20/12/2021

**The new Sydney Fish Market - Stage 2 (SSD-8925-MOD-6)
Request for additional information**

DRAWING TITLE:
Ground Floor Plan

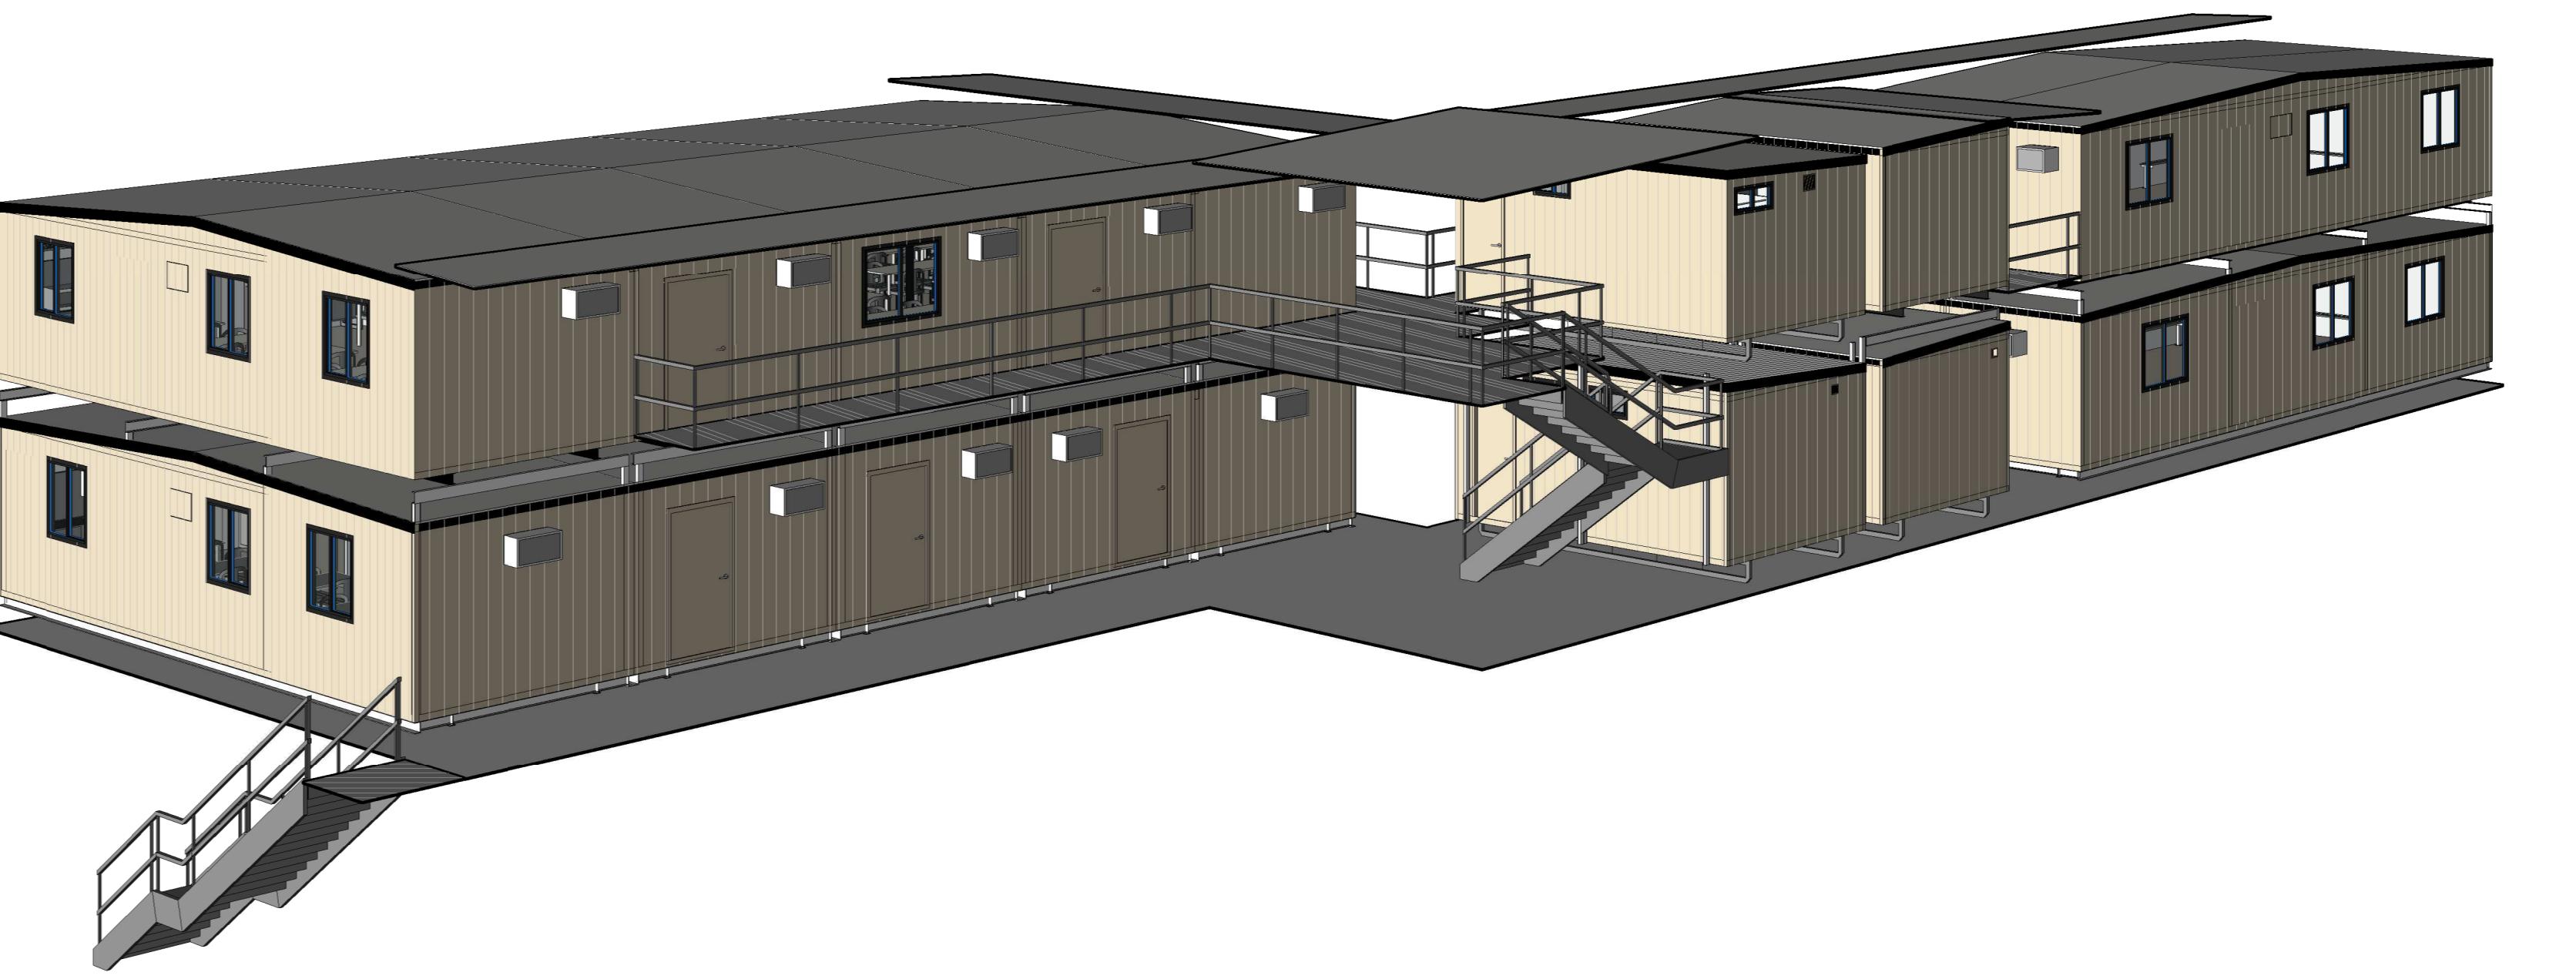
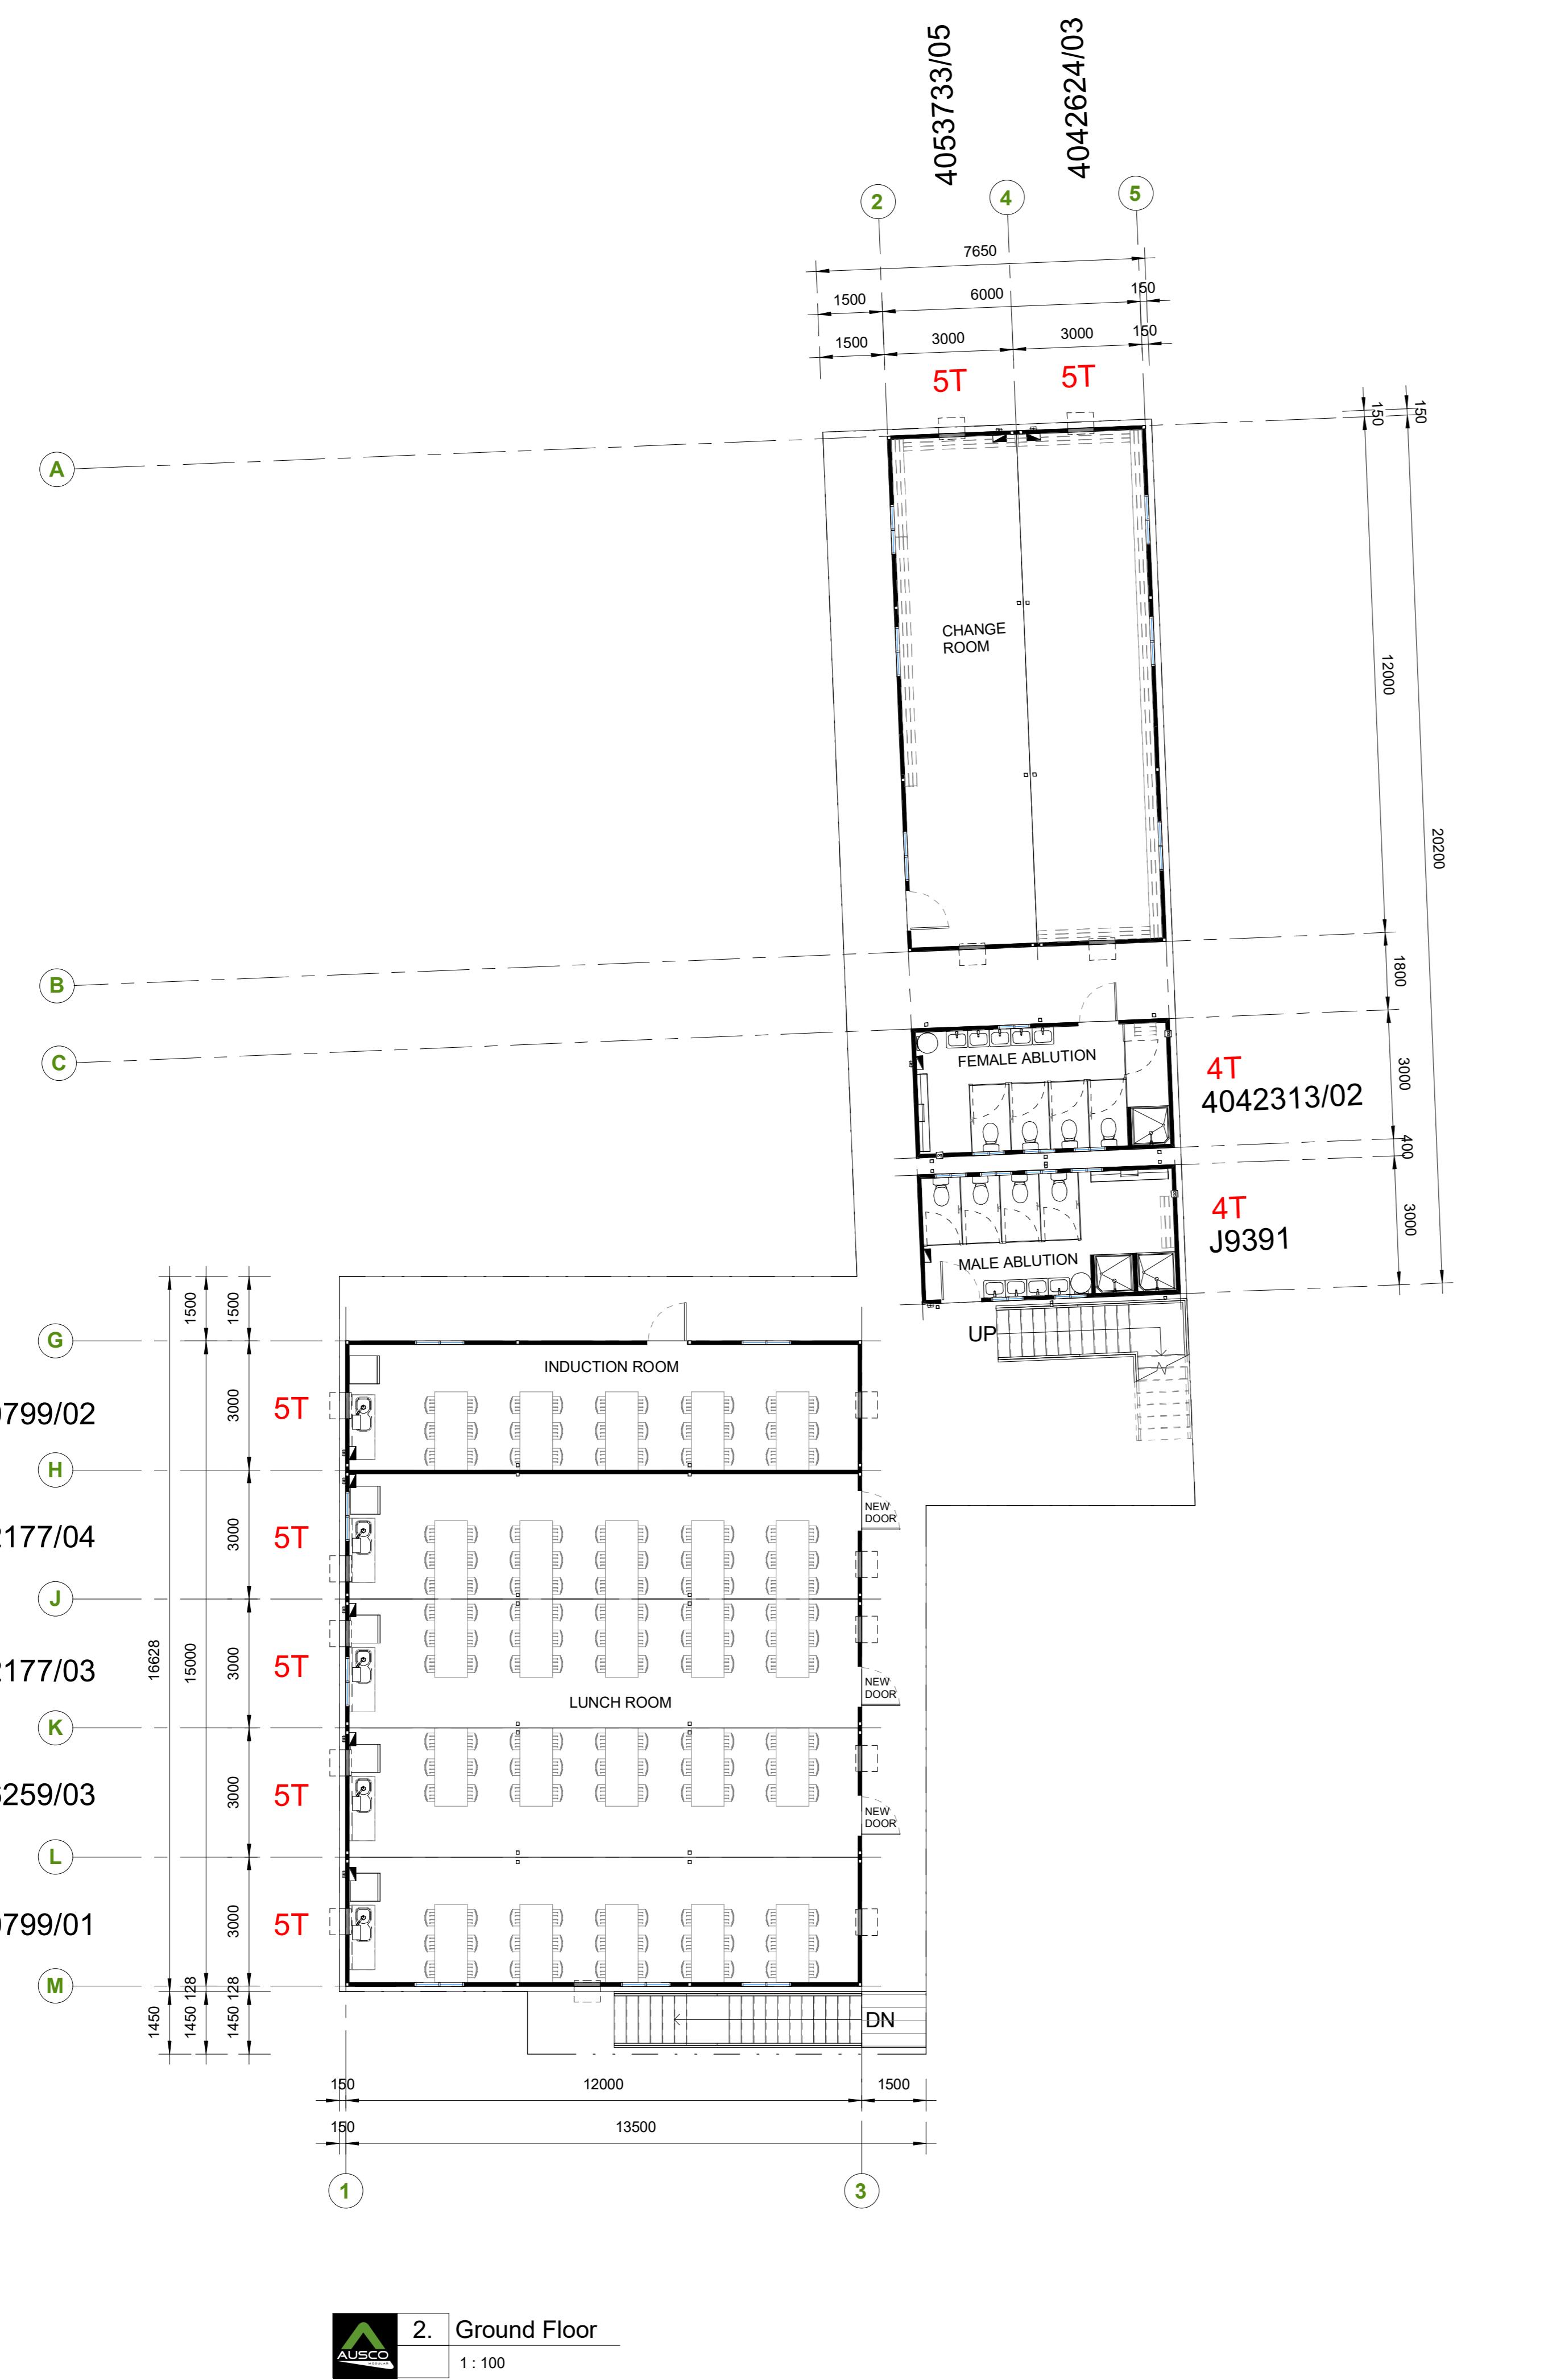
- Confirm how access is provided between the ground floor and first floor. The location of any staircase shall be shown on the architectural plans.
- Label the elevation drawings (Drawing No 110-112)
- Confirm the amount of additional truck movements during installation and dismantling and the timeframe for installation and dismantling within Section 2.10 of the Construction Management Plan.
